RE: Planning Application WSCC/096/13/F Grundon Waste Plant at Ford

Ford Parish Council objects to the above Application based upon the points made in this letter.

Planning application WSCC/096/13/F Grondon Waste treatment facility at Ford

Title  
EAST ACCESS WORKS

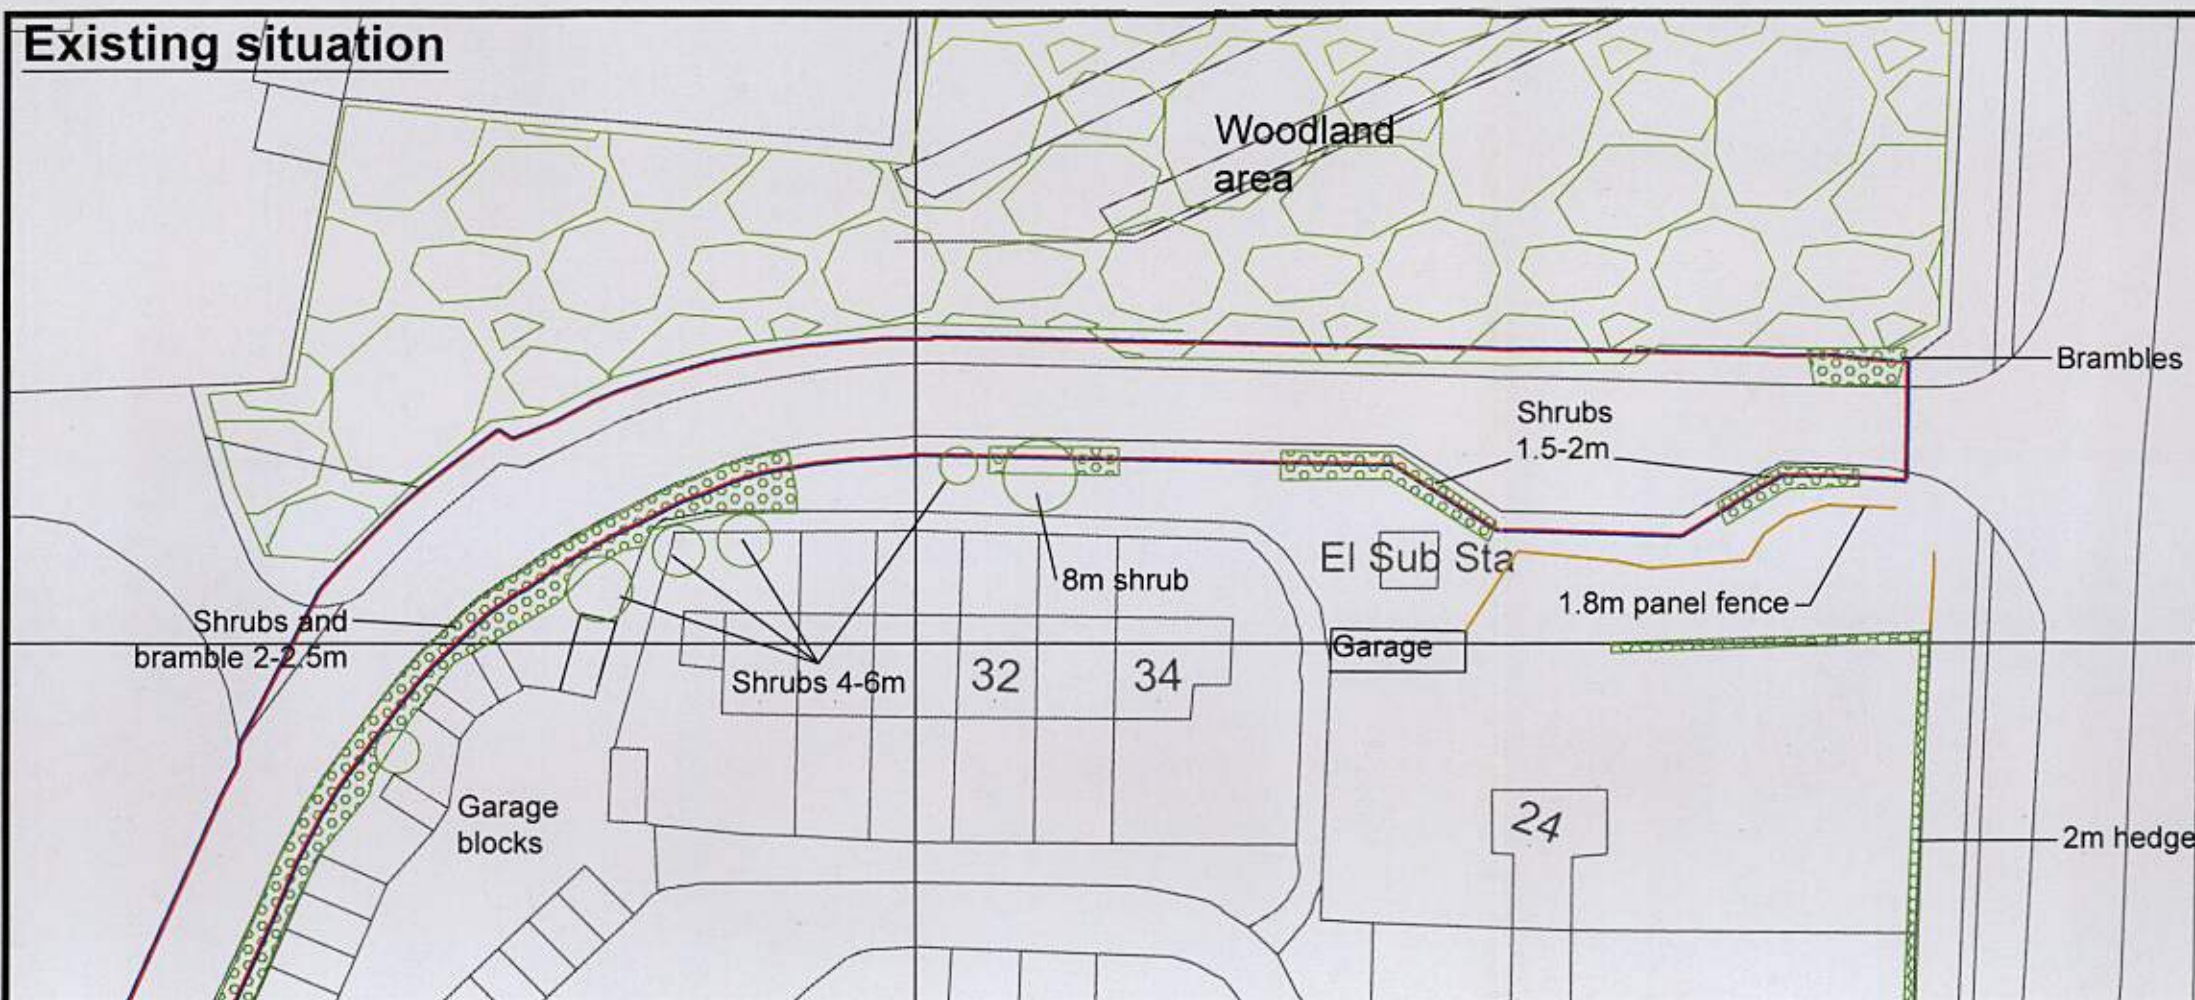
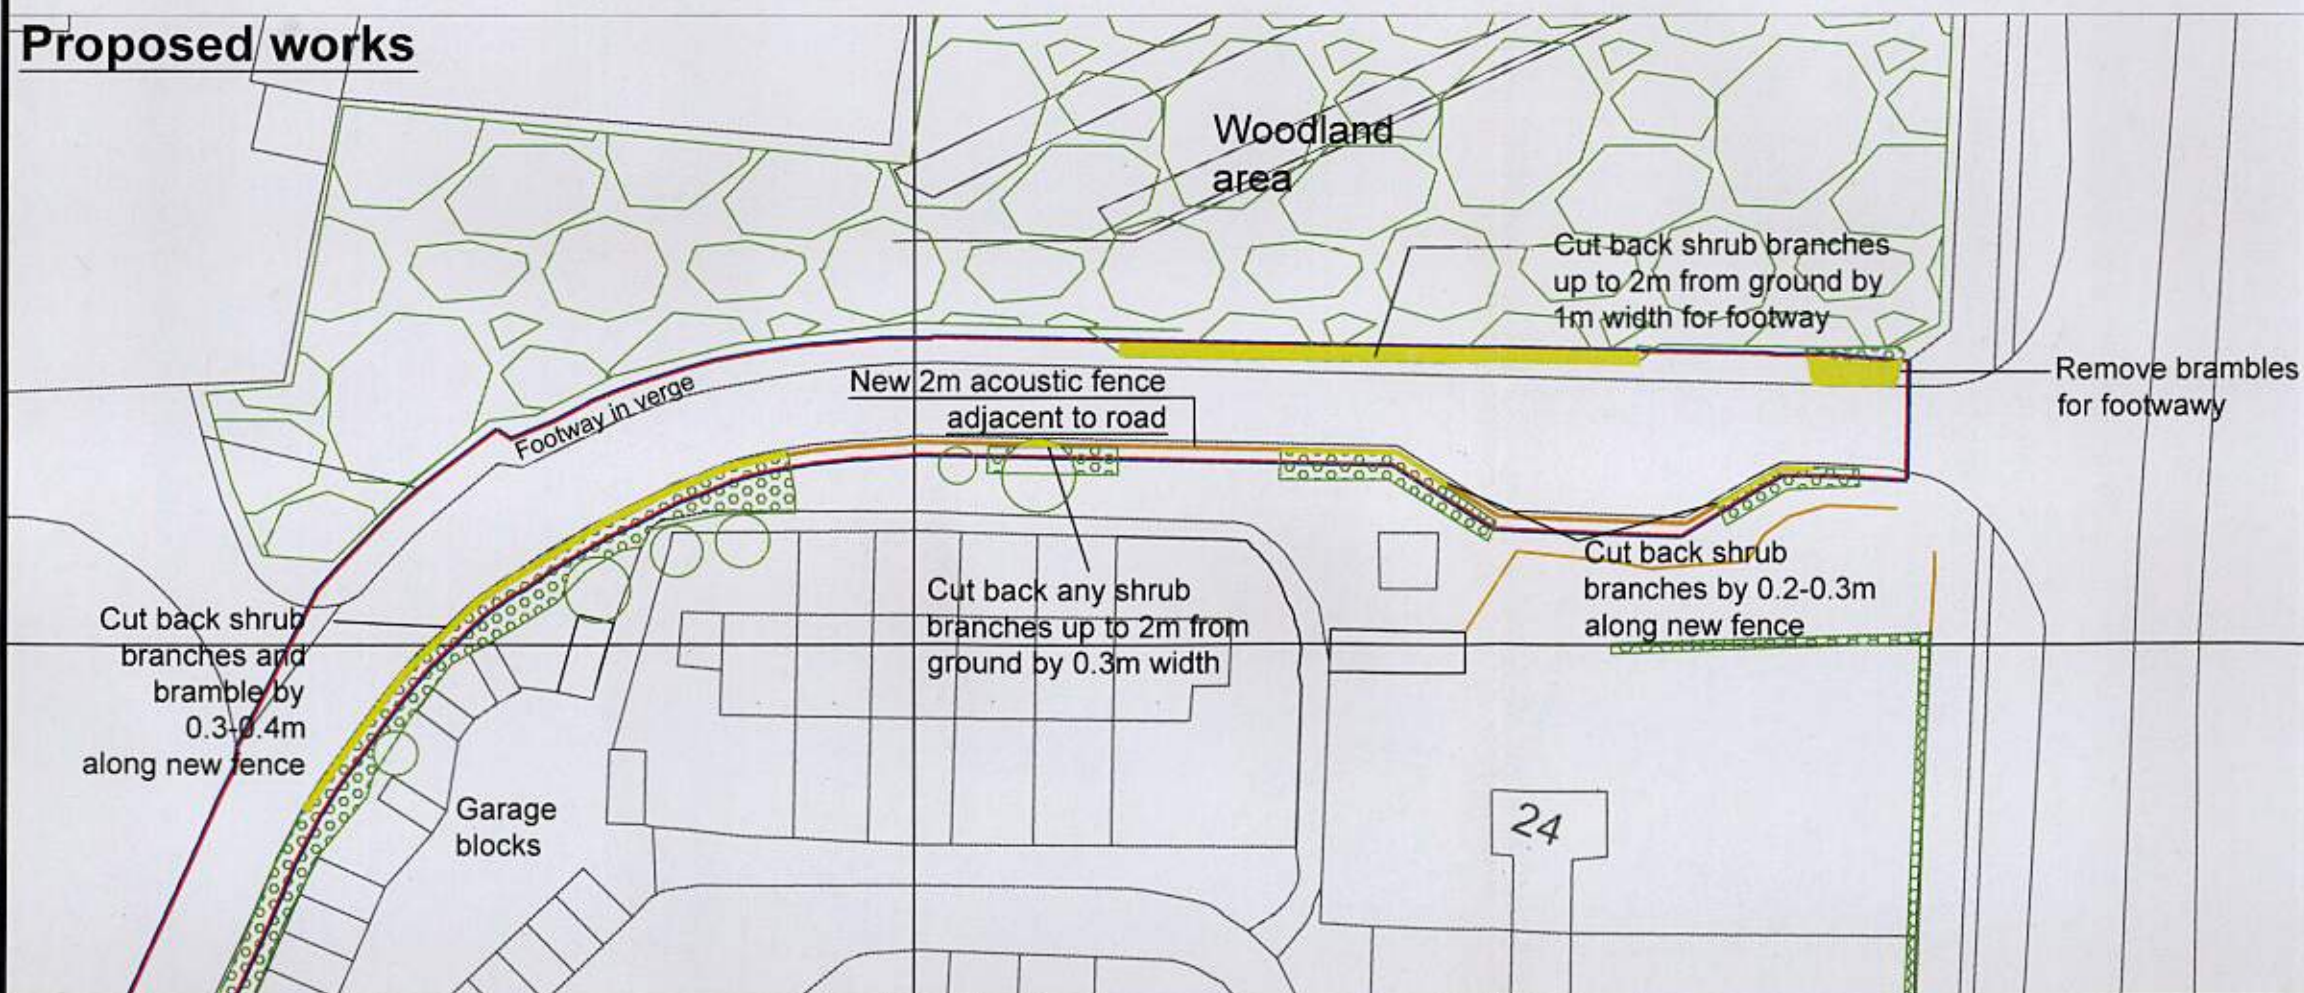
- x) There is not safe and adequate means of access to the highway network from the site as the access/exit route travels along a public footpath for a considerable length.

Non-compliance. Entrance road is too narrow to split between HGV's and pedestrian users. It appears they do not own the land shown as a new footpath.

0200/13 A member of the public noted that no pedestrian crossing was offered across Rollaston Park as part of the proposal. It was stated the neither Rollaston Park nor the road behind Rodney Crescent were wide enough to cope with any large vehicle movements.

0205/13 A member of public said that the exit by Rodney Crescent is unacceptable for use by HGV's. To exit the road they have to swing out over both lanes and cars are forced off the road. The children wait their for their school bus and this is unacceptable.

Title
ELEVATIONS

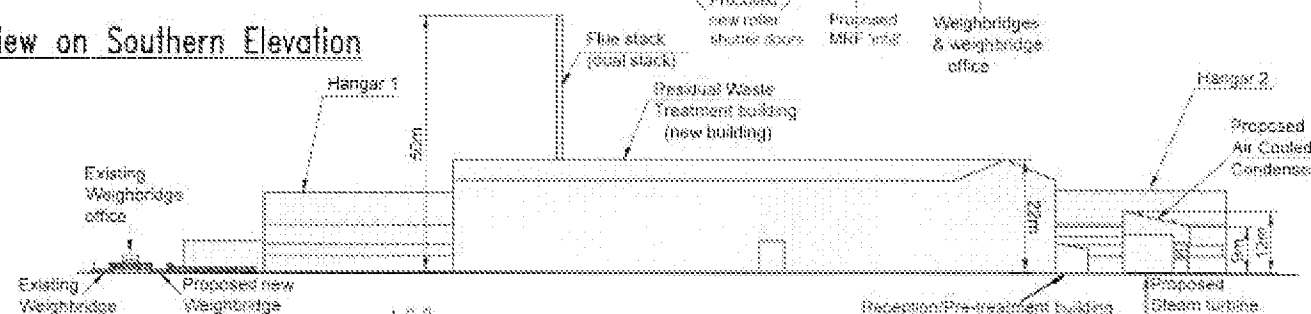
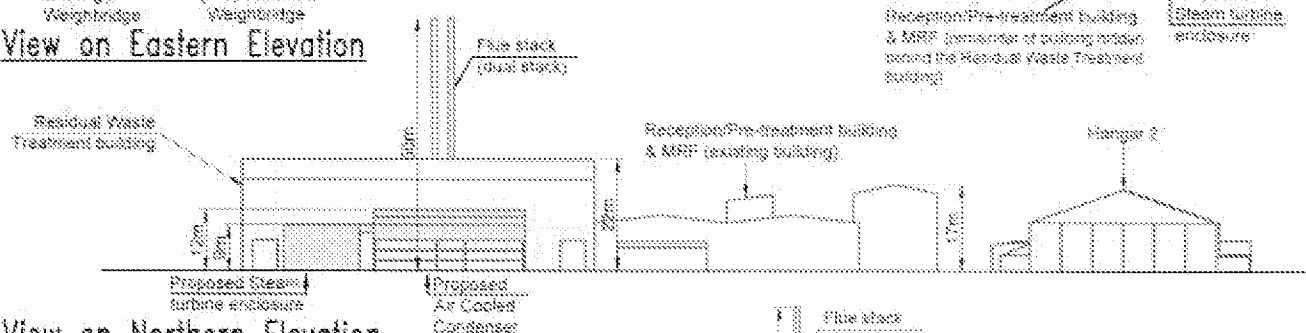
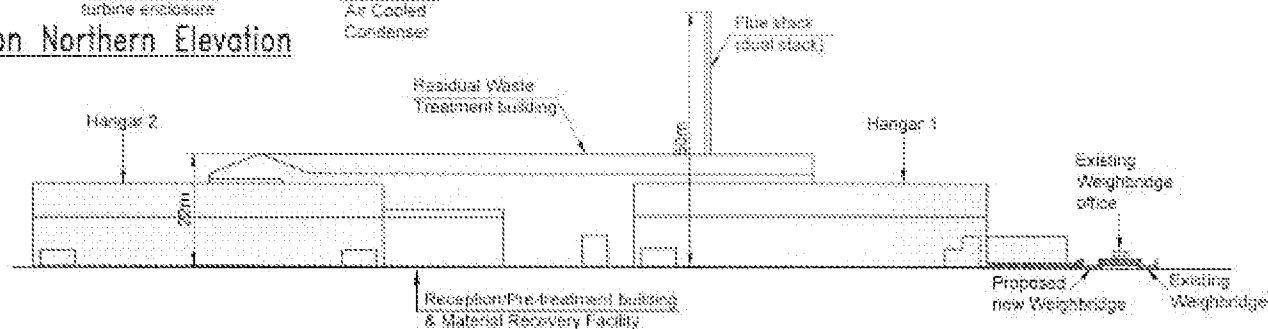
Proposals for new built waste management facilities within or close to the South Downs National Park and the Areas of Outstanding Natural Beauty will also be judged against the criteria in Policy W13. Two fifty metre chimneys at this location breach these guide lines.

There has been no effort to protect or enhance the landscape and character of Ford or West Sussex. The views south from Arundel, north from Clymping, east from Yapton and West from Lyminster and Littlehampton will be ruined by the chimneys.

We have serious concerns about the emissions from the two fifty metre chimneys into the surrounding atmosphere. We believe there is a serious health risk to the new housing being built at Courtwick, other areas of Littlehampton, and beyond as far as Worthing. We seek assurance that there will be no health risk to residents of these communities from Dioxin emissions. What safeguards are in place to prevent the emission of Dioxin. We would like to see base line figures established at various locations in the area and for these to be monitored if the application is approved.
